Addendum No. 1

RE: Contract ID: C201732

Beaufort, Pitt County (B-4020)

Bridge over Tranter's Creek and Approaches on SR-1403 &
SR-1567 in Washington.

LT. WT. AGGREGATE = 3600 TONS * To be used in place of earth embankment from Station 16+25 to Station 19+98

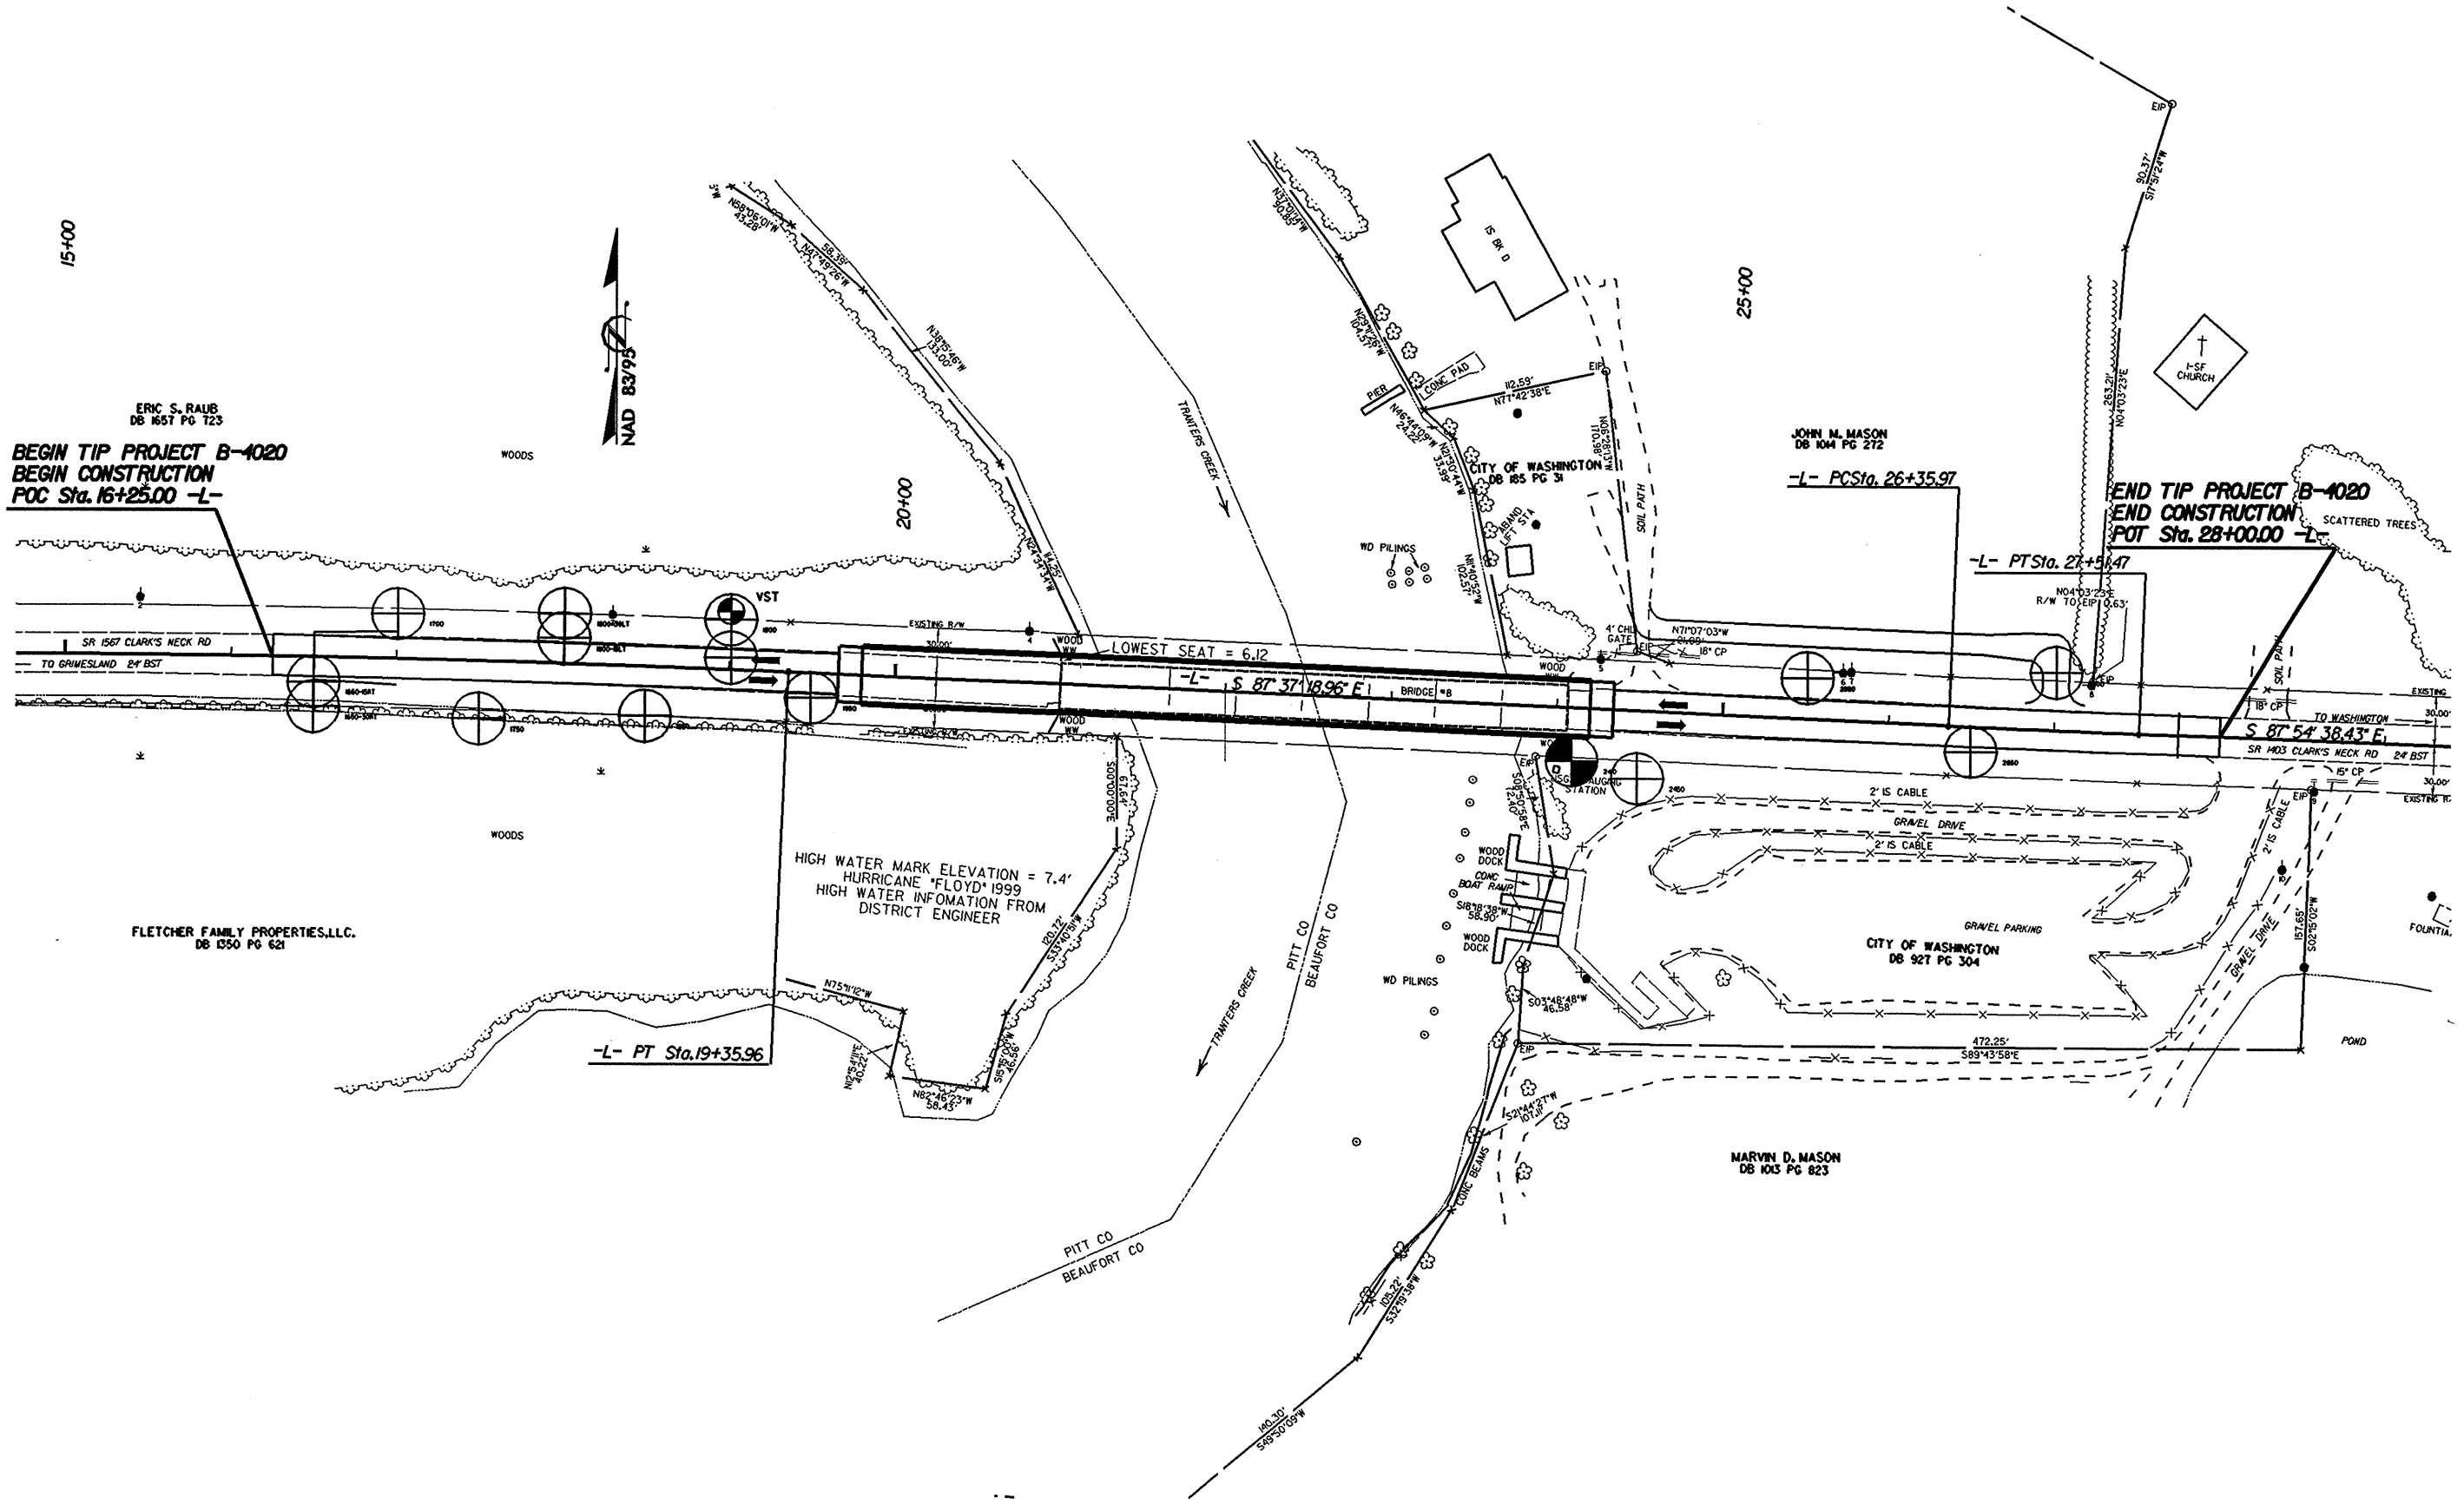
The Earthwork Balance sheet in the subsurface plans has been revised to reflect the above revisions. Please void the Earthwork Balance sheet in your subsurface plans and staple the revised sheet thereto.

LIGHTWEIGHT AGGREGATE EMBANKMENT (TYP. SECTION A-A)
N.T.S

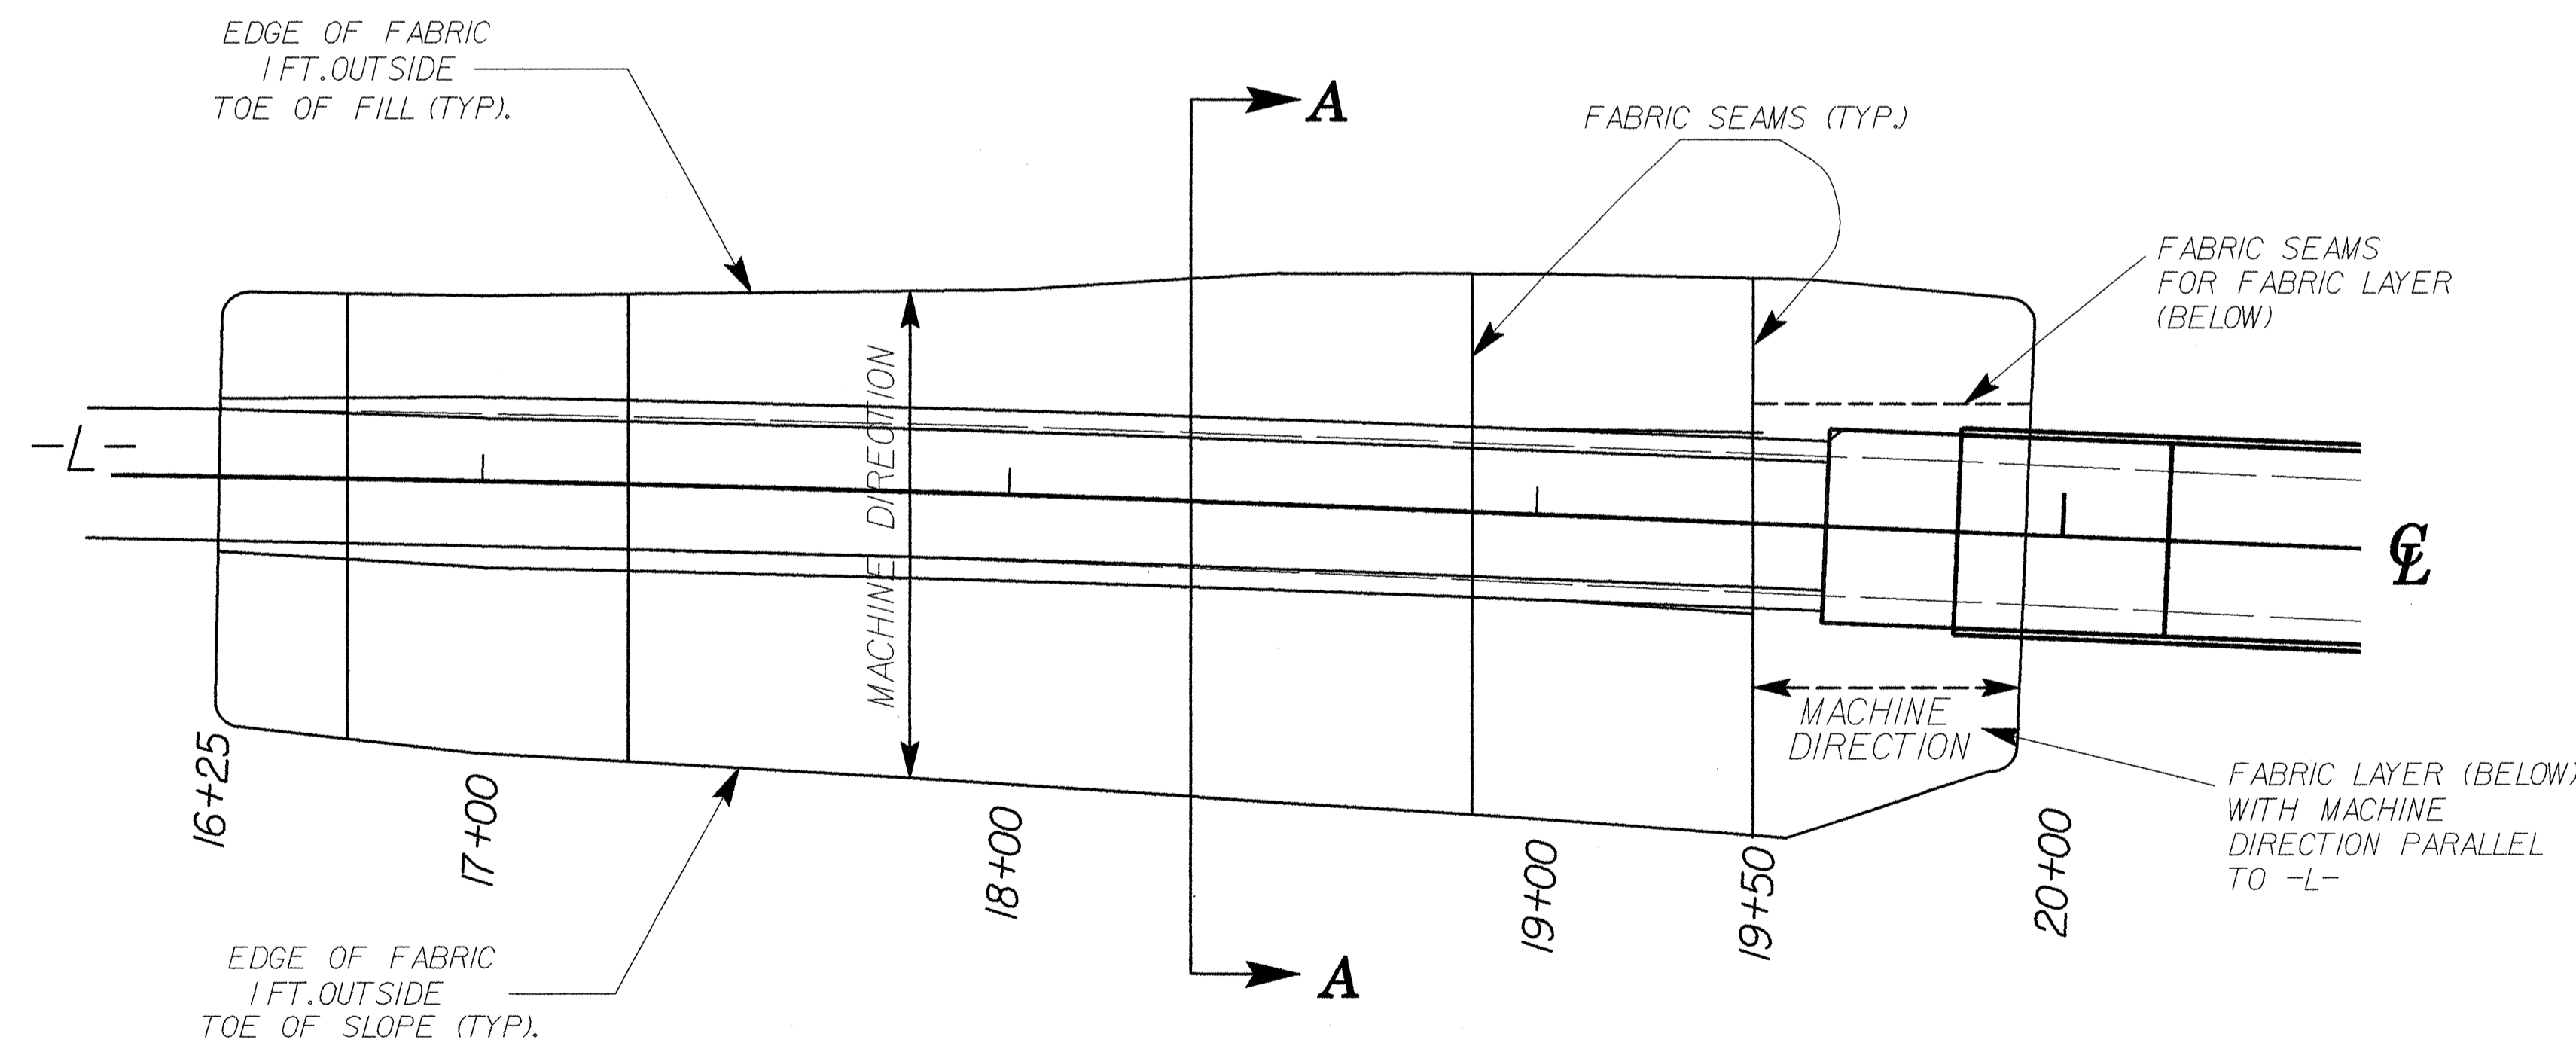
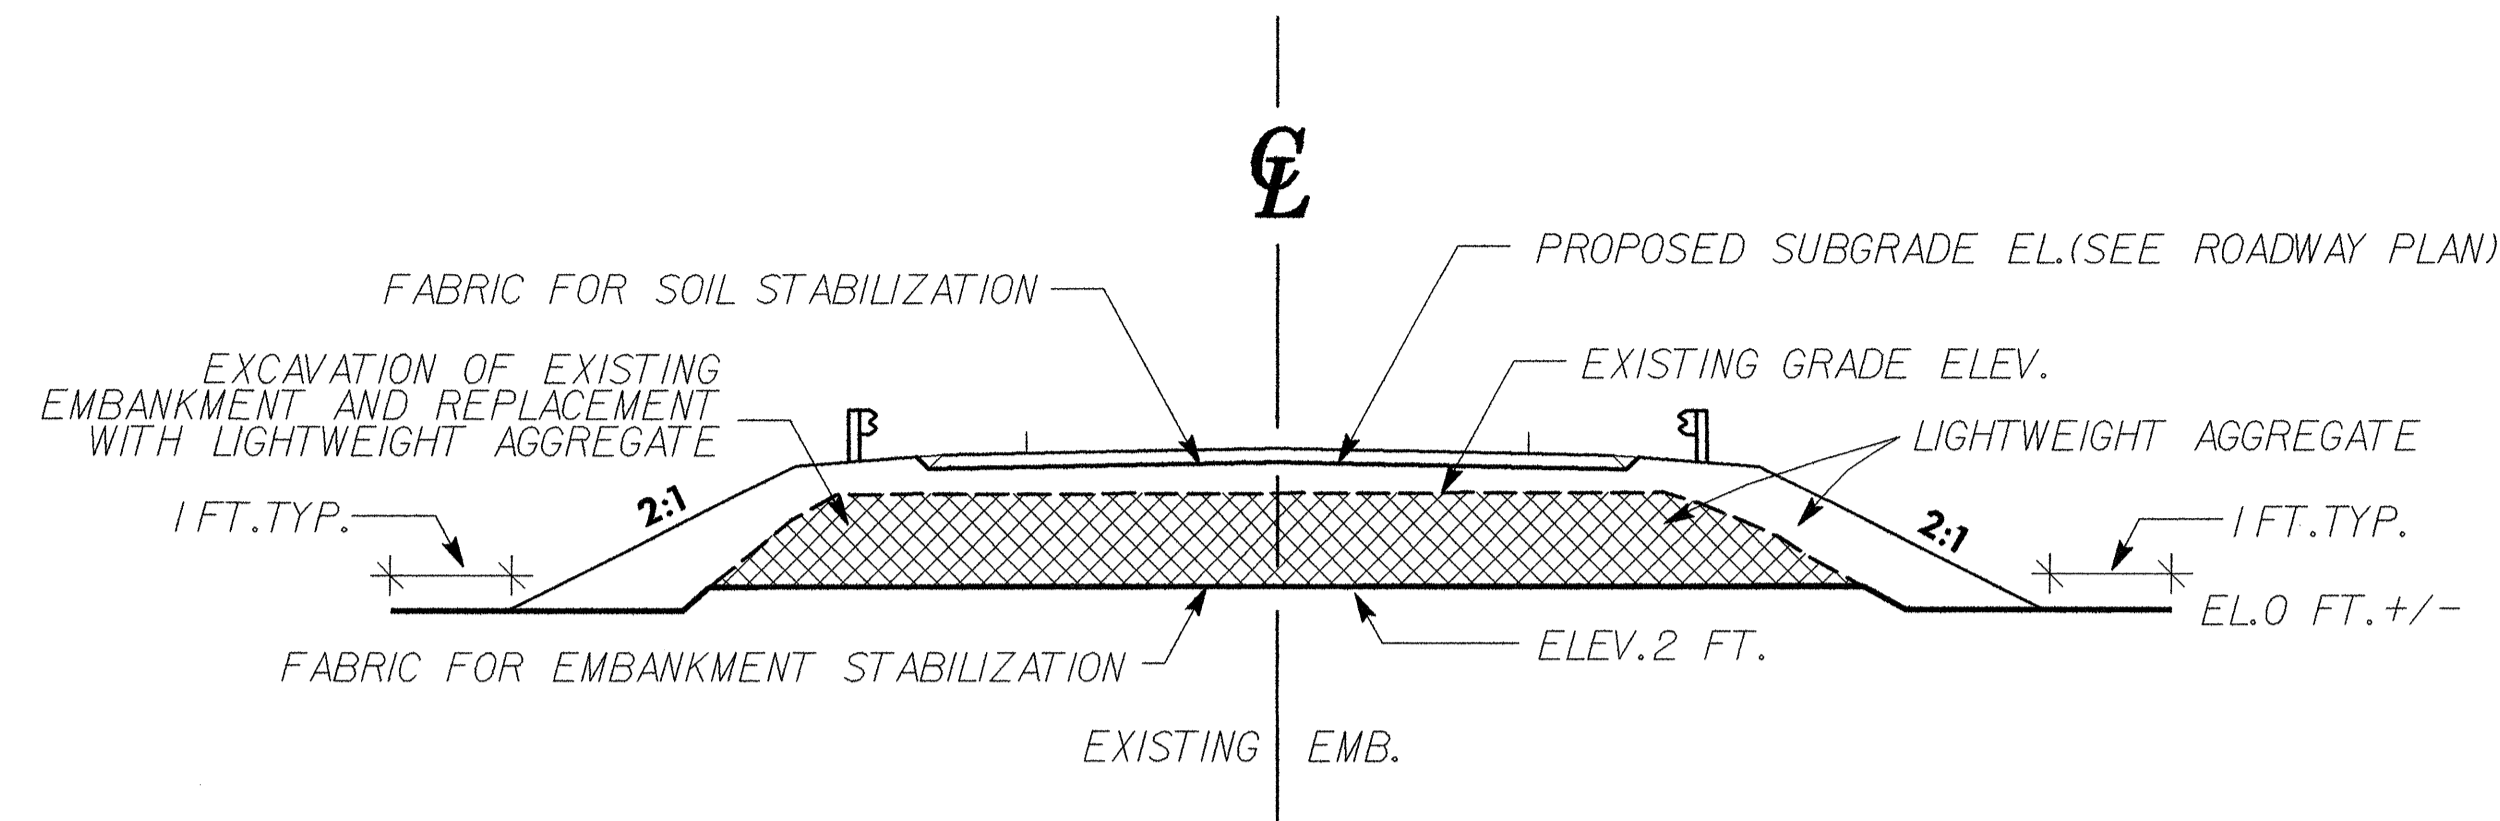
Sheet Nos. 3A and X-1 have been revised to indicate the use of lightweight Aggregate as backfill. Please void Sheet Nos. 3A and X-1 in your plans and staple the revised plan sheet Nos. 3A and X-1 thereto.
